DEVELOPMENT REVIEW BOARD
SUPPLEMENTAL SUBMITTAL

PROJECT NO. PR-2018-001405
Application No. SD-2022-00100

Re: Final Plat Review for Proposed Subdivision of Tract B, Nuevo Atrisco

**Plat for
 Tracts B-1, B-2, and B-3
 Nuevo Atrisco
 Being Comprised of
 Tract B
 Nuevo Atrisco
 City of Albuquerque
 Bernalillo County, New Mexico
 June 2022**

NUEVO ATRISCO
201 Unser Blvd NW
Albuquerque, NM 87121

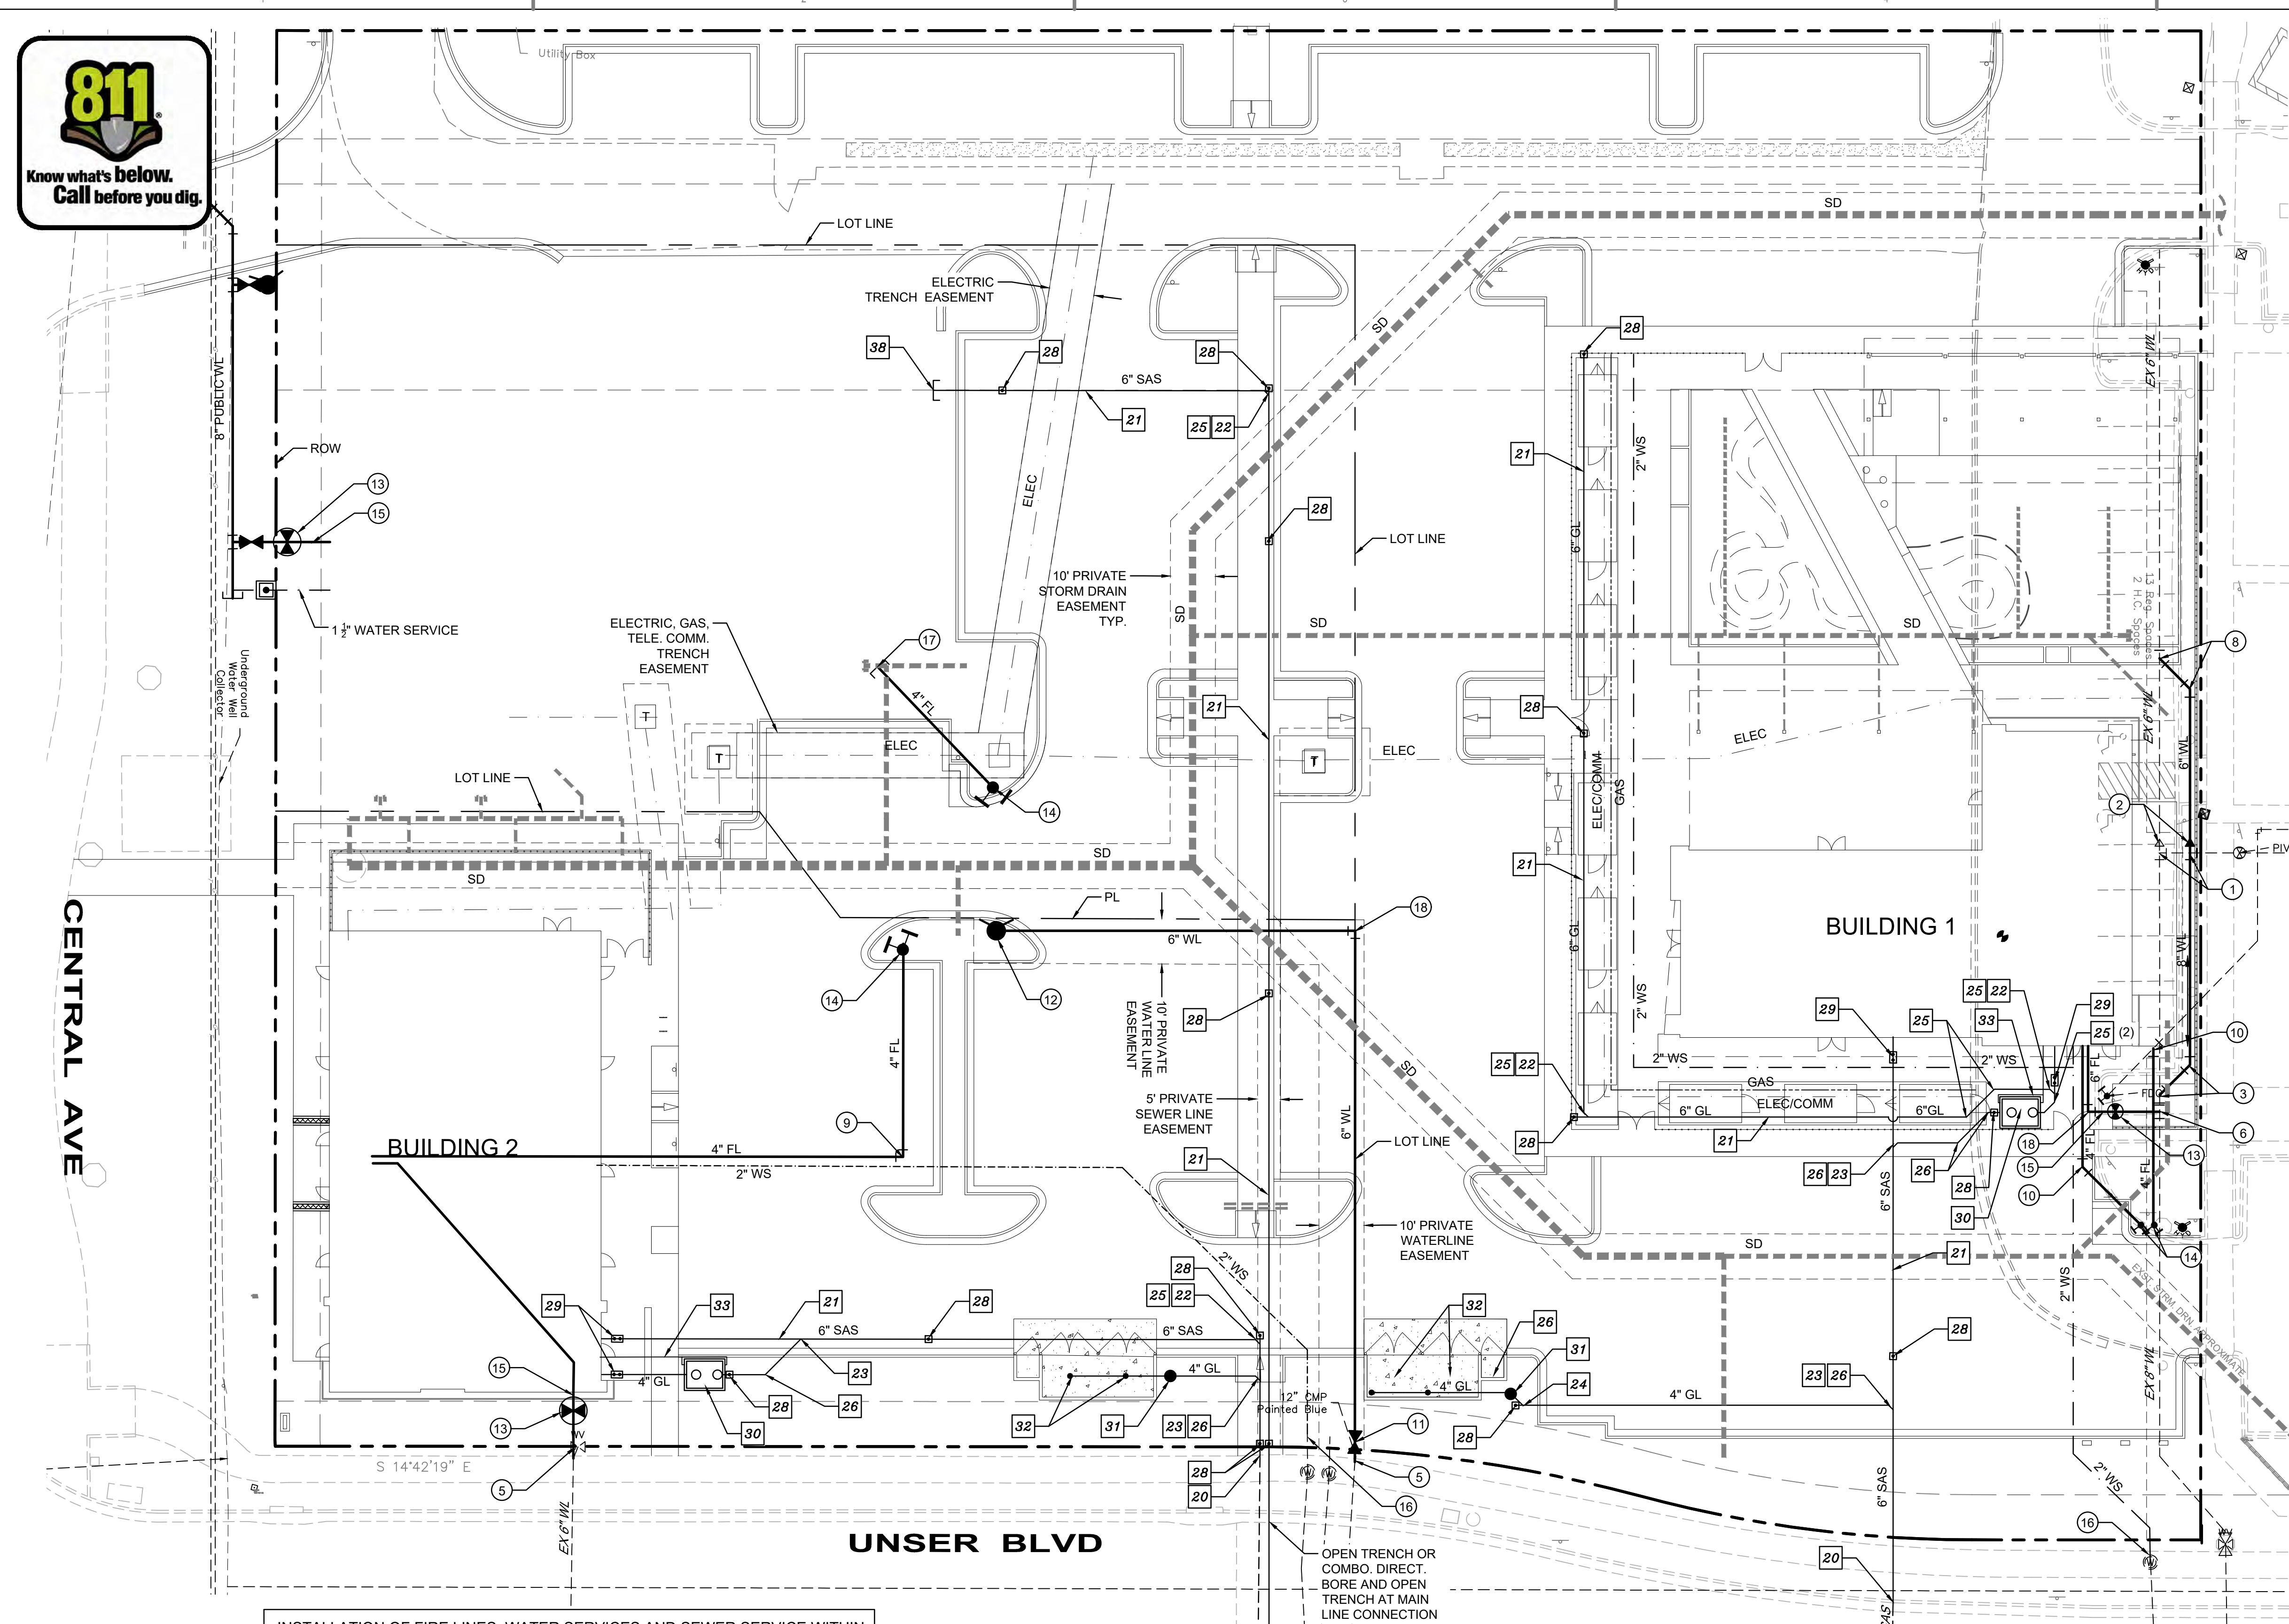
2. Utility Plan
 - a. Is the proposed 6" waterline near the southwest corner of proposed Lot 3 public or private? It seems as though it is proposed as public given a proposed meter is connecting to it. The proposed alignment may be better suited if it is a straight line within public right-of-way without bends. The

proposed private fire line and domestic water service can take perpendicular service from this proposed line.

- i. What is being served by the existing 6" waterline stub that is being connected to? Please confirm it is not a private fire line. The as-built for City Project No. 4383.91 seem to indicate a non-pressure connection at the northern terminus of this line (station 13+56.90, 127.60' LT).
- b. Why is there a proposed 5' private water easement on proposed Lot 2 for the private fire line that serves proposed Lot 2?
 - i. Update: This appears to serve the FDC for Lot 2 and Lot 3. Sharing a private hydrant is not allowed by ordinance. A public hydrant off the extension south of Lot 3, and relocating this FDC to the south side of Lot 3, may be the most appropriate solution.

- c. Please confirm proposed Lot 2 and Lot 3 have separate sanitary sewer services? It appears that Lot 2 will be utilizing an existing 6" private sanitary sewer stub from Unser Blvd. which is separate from Lot 3. Please confirm.

Per client instruction we have removed easement [14], which would have been the private fire line discussed below. The architect and engineer deemed the easement unnecessary.

Please see site plan supplement for confirmation of water and sewer service independence for Lots 2 and 3.
